**WEST SUSSEX COUNTY COUNCIL
STRATEGIC PLANNING CONSULTATION**

SUBJECT: EP/76/12 - Proposed change of use of office building (B1 Business) to residential (C3 Dwelling Houses), forming 2 x 2-bed flats.

I C I S Information for Life, 35, Worthing Road, East Preston, West Sussex, BN16 1BQ

Drawing Title
Proposed Site Layout

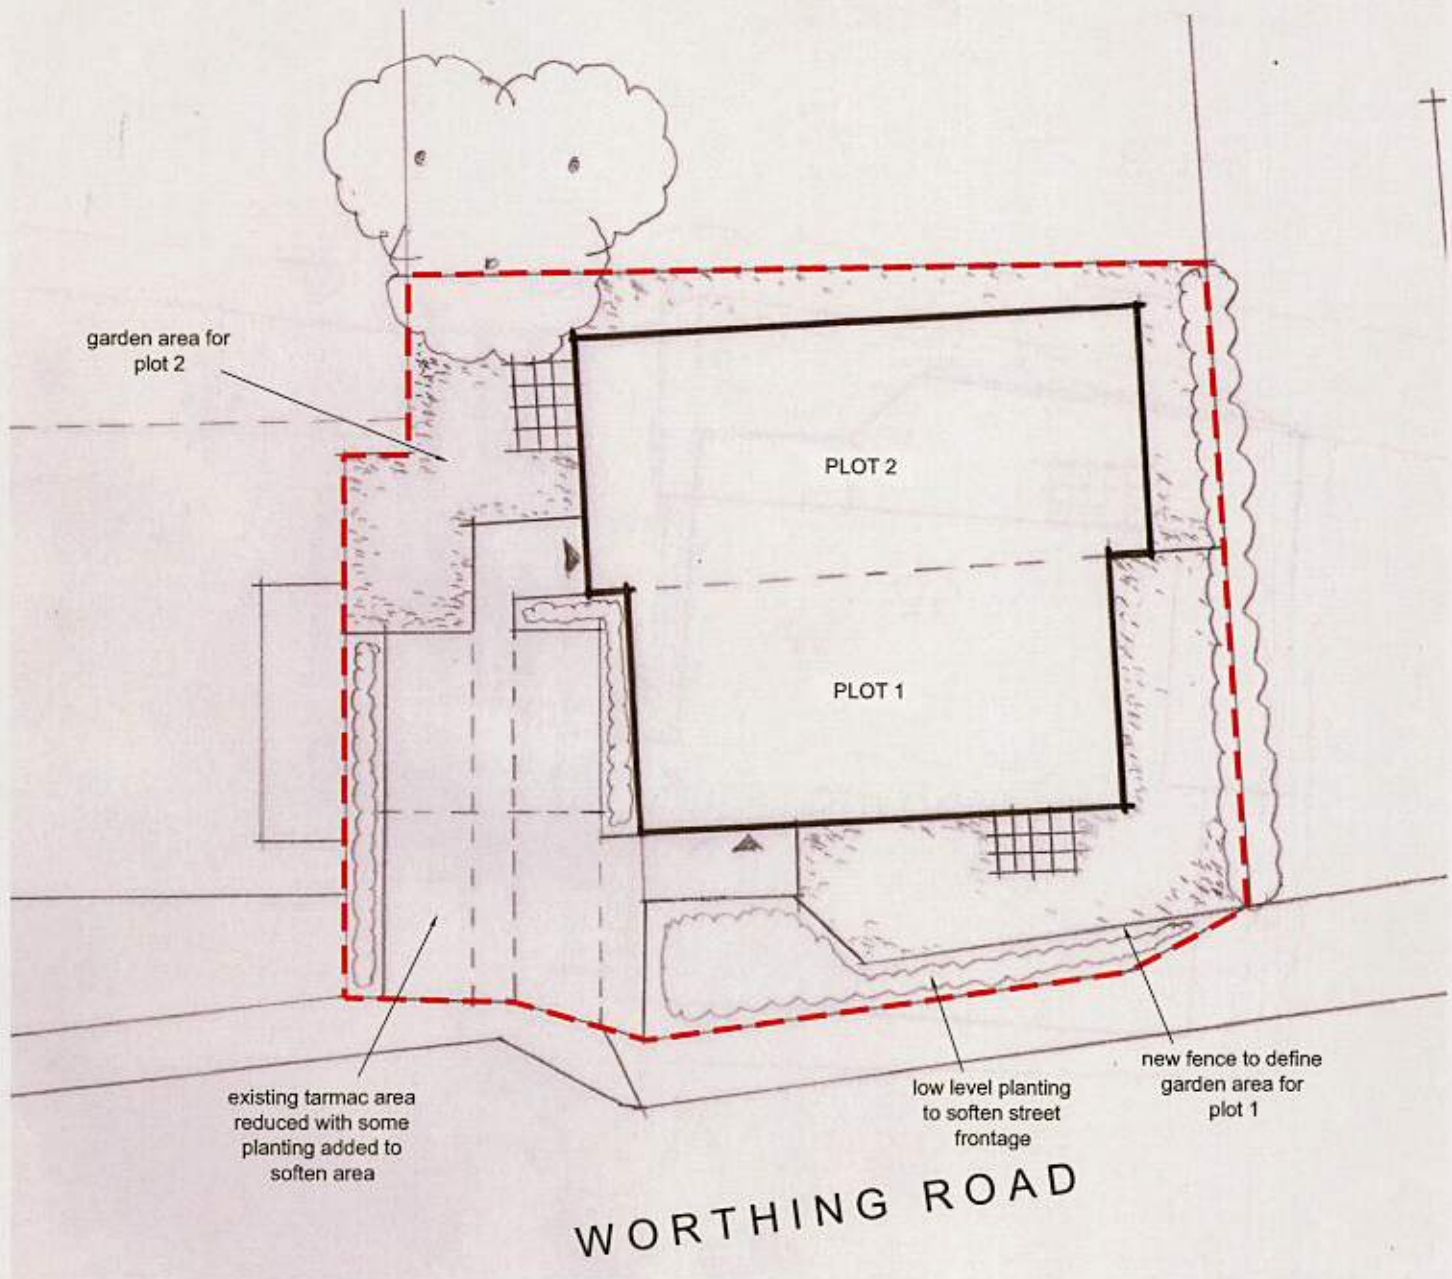
This application appears to be for the change in use from office space to facilitate 2 x 2 bedroom flats. From inspection of the plans and information available, the proposal includes 4 off street car parking space, which having checked WSCC car parking demand calculator meets the needs for this area. There is no facility to allow cars to turn on site, allowing them to exit on to the highway in the forward gear; however giving the nature and the 30 mph speed limit on this road, together with the fact that it would have been operating similarly this way for a number of years, there would not seem to be an issue.

The visibility at this access point looks to be adequate in both directions. I have checked the most recently verified accident report data which reveals a traffic collision close to the vicinity of this access. However, after thoroughly checking this data, it does not directly link to an issue with this site.

The area is situated in a sustainable location and within walking distance to bus stops, local shops and Angmering Train Station. The provision of the 4 cycle spaces should be secured by condition.
